Our Ref: FP/121/11/

10th August 2011

Two storey rear extension. Gable extension to front to include 2 balconies. Re-submission following FP/6/11/

Seacroft Outram Road Felpham Bognor Regis

Proposed Rear Elevation

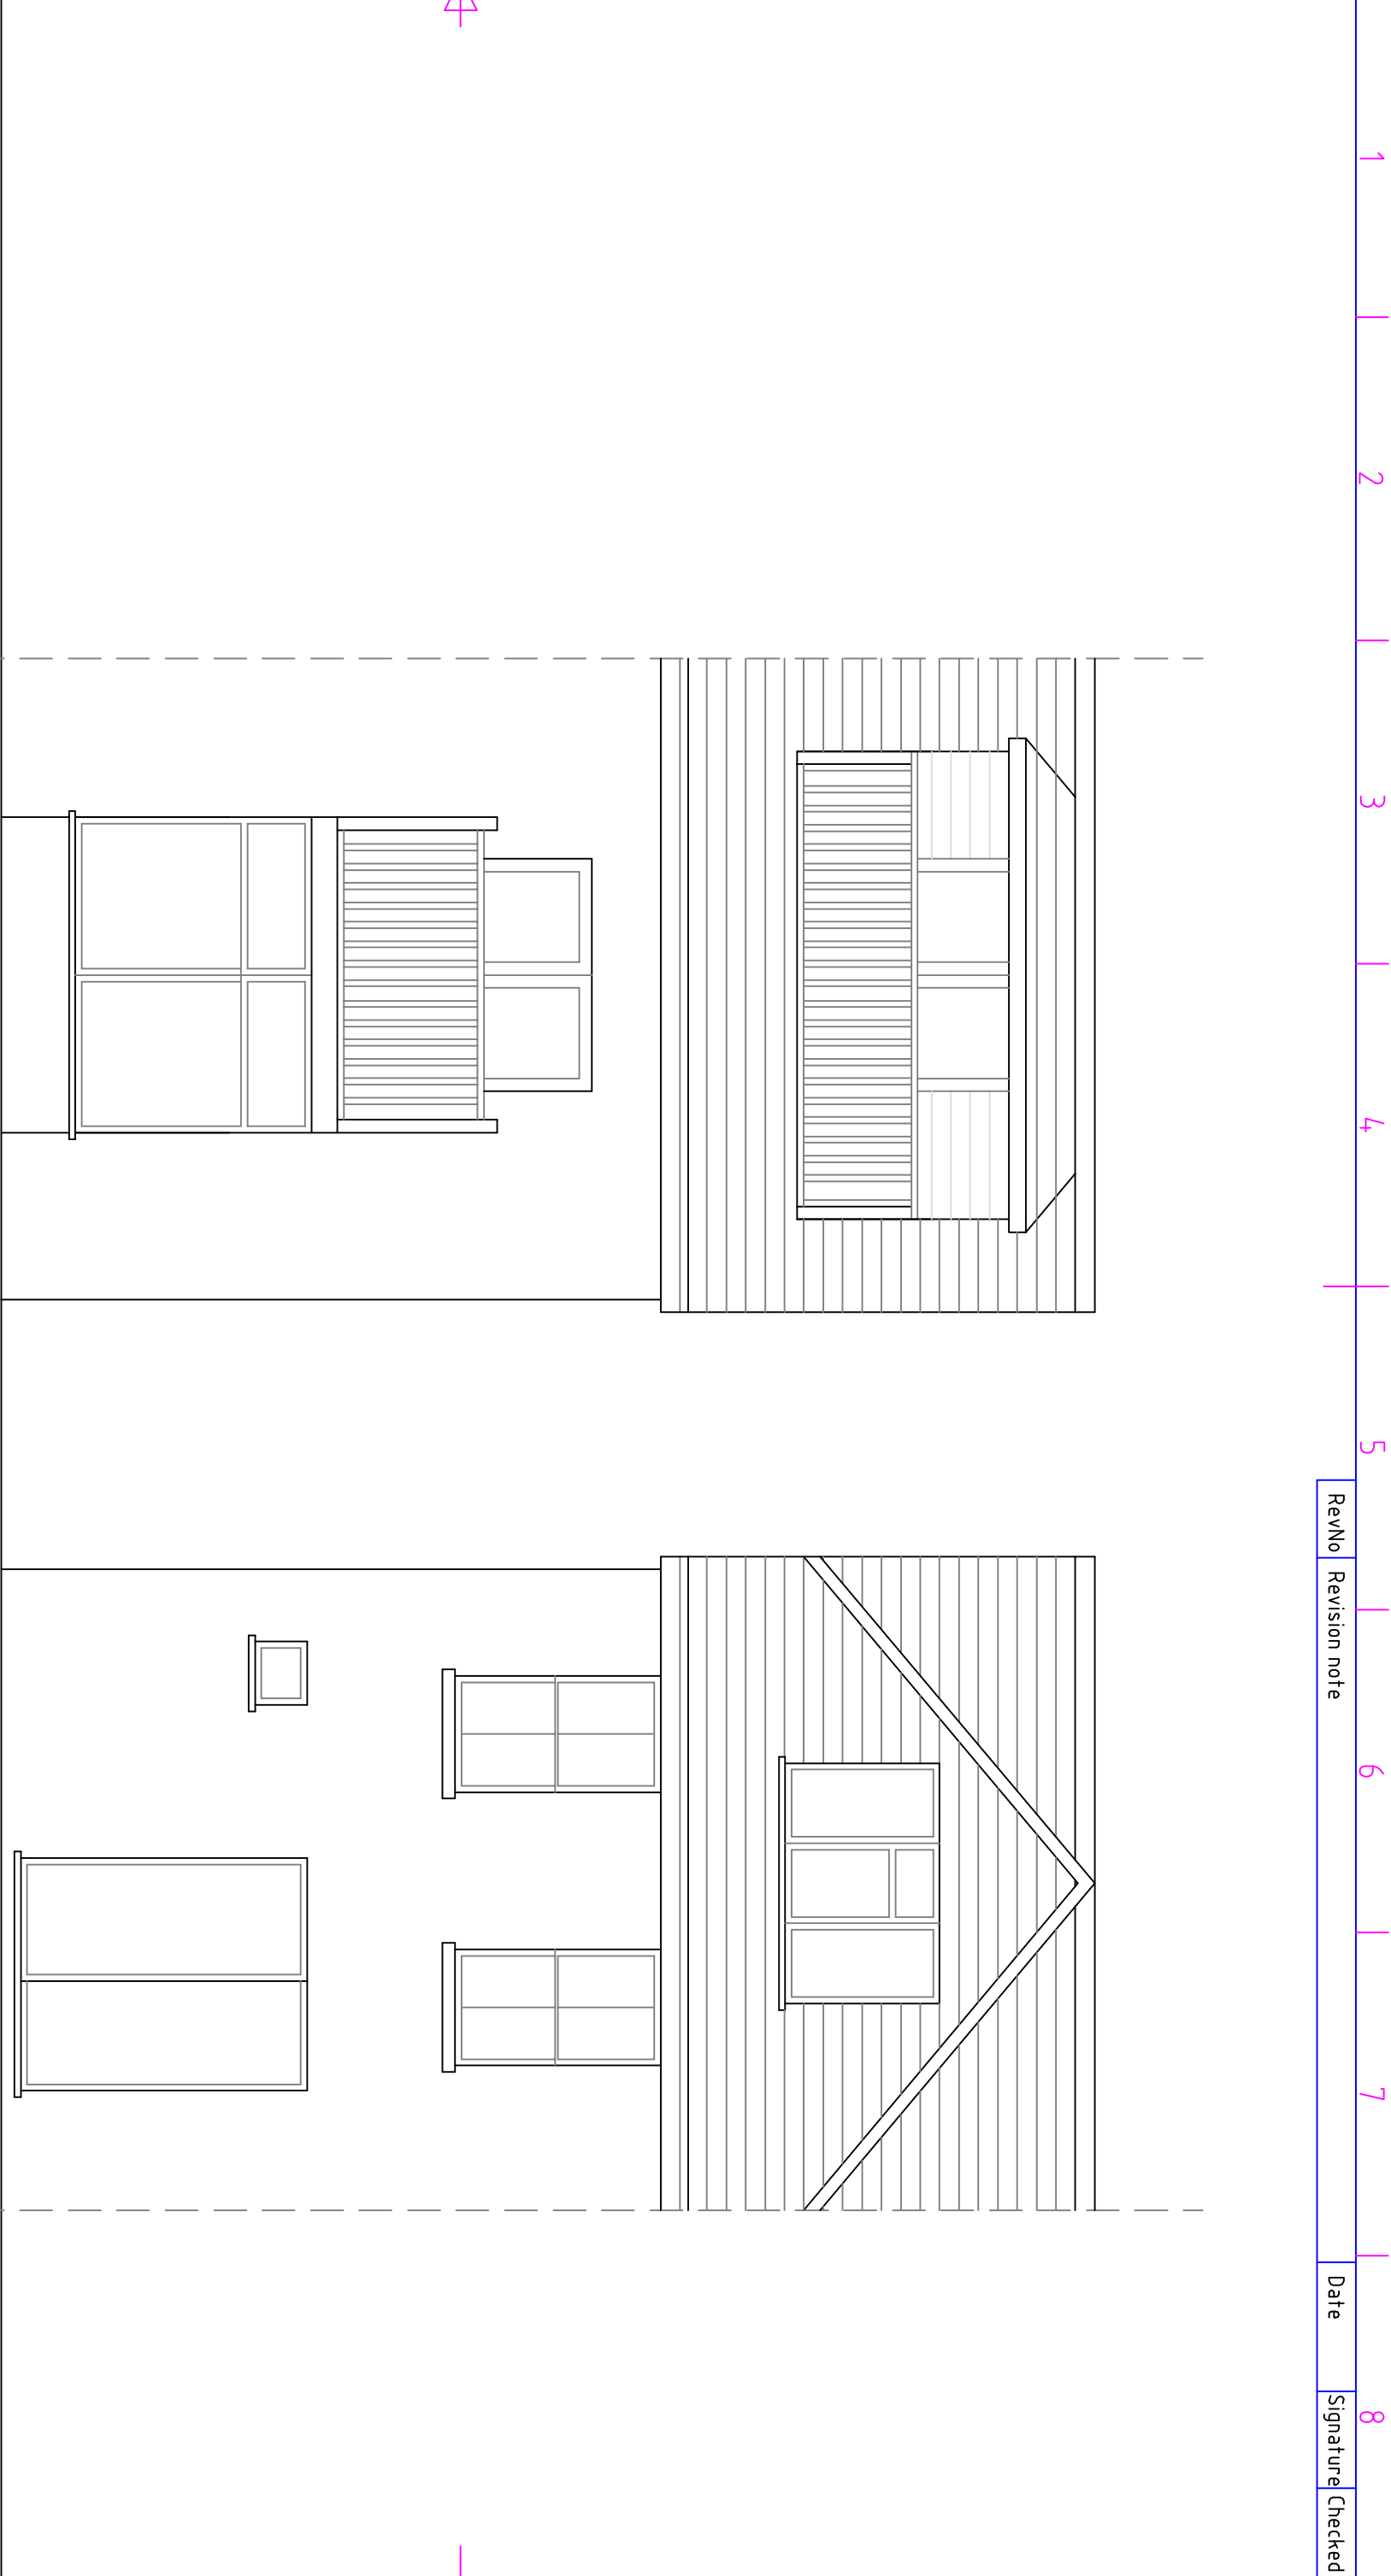
The proposed rear extension would result in an unacceptable loss of light and have an overbearing impact on the adjoining residential properties

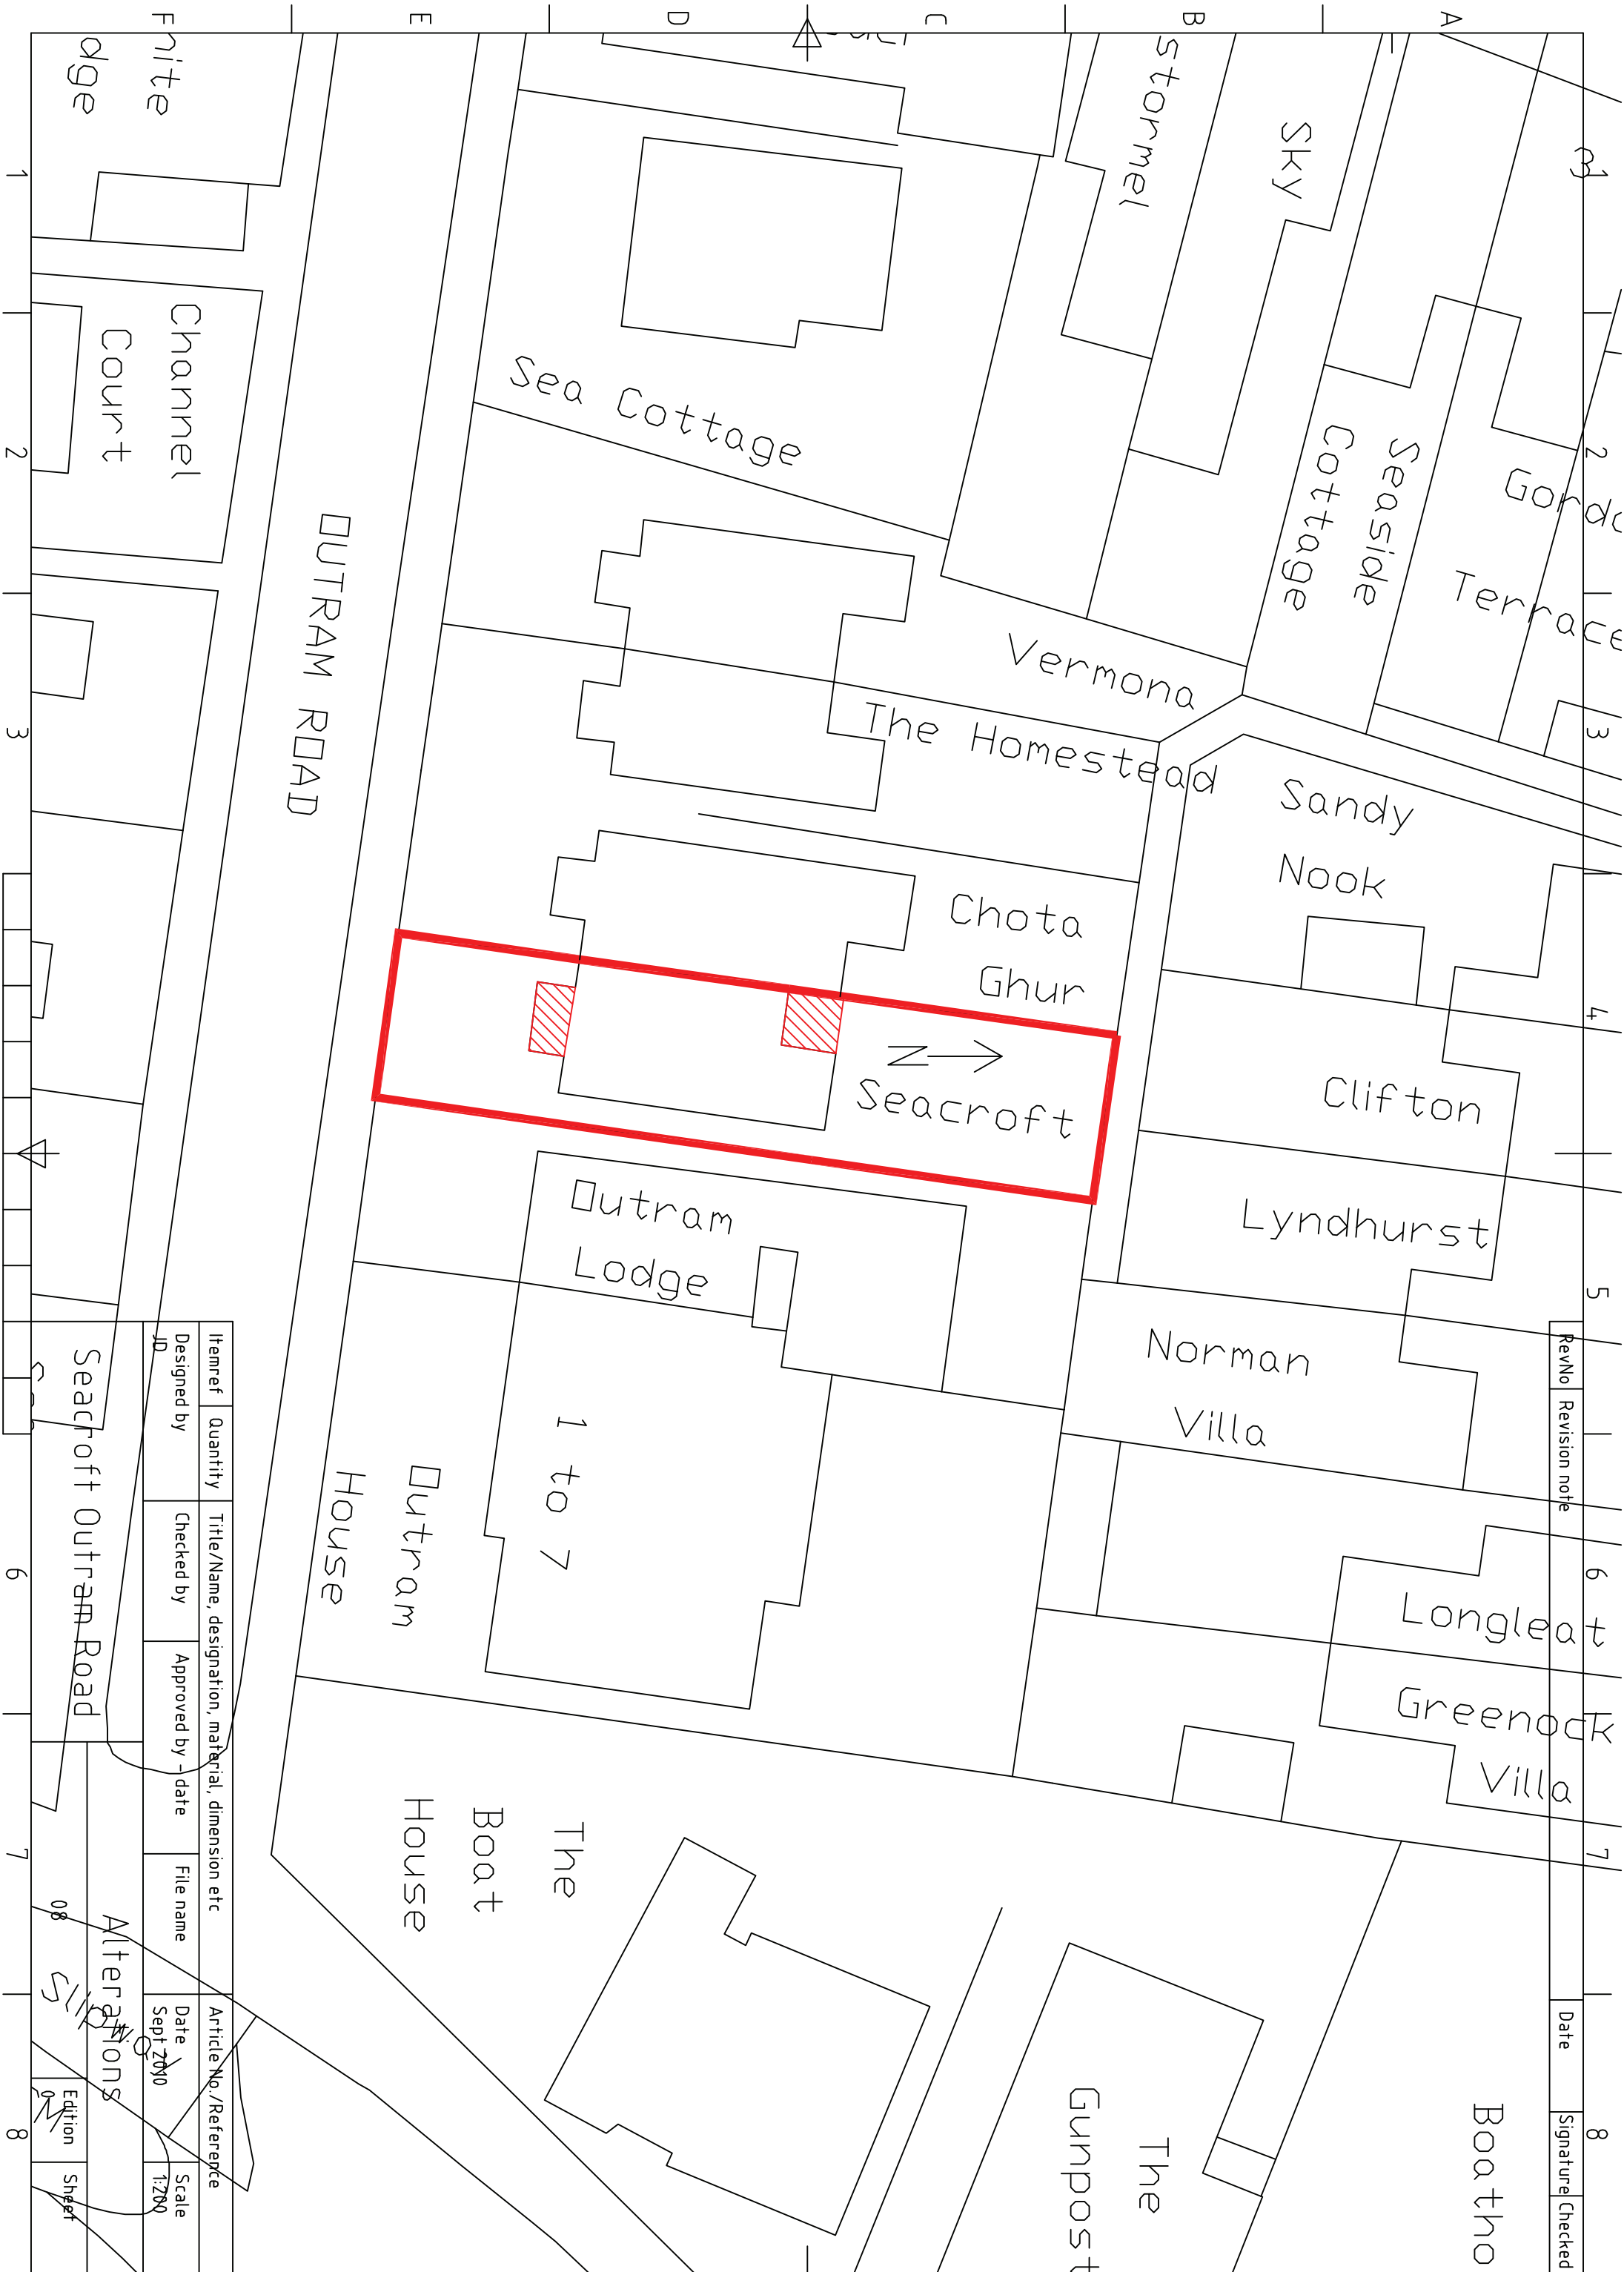
The site plan is misleading - at the rear of the property a cross hatched section is shown but it is unclear what this is.
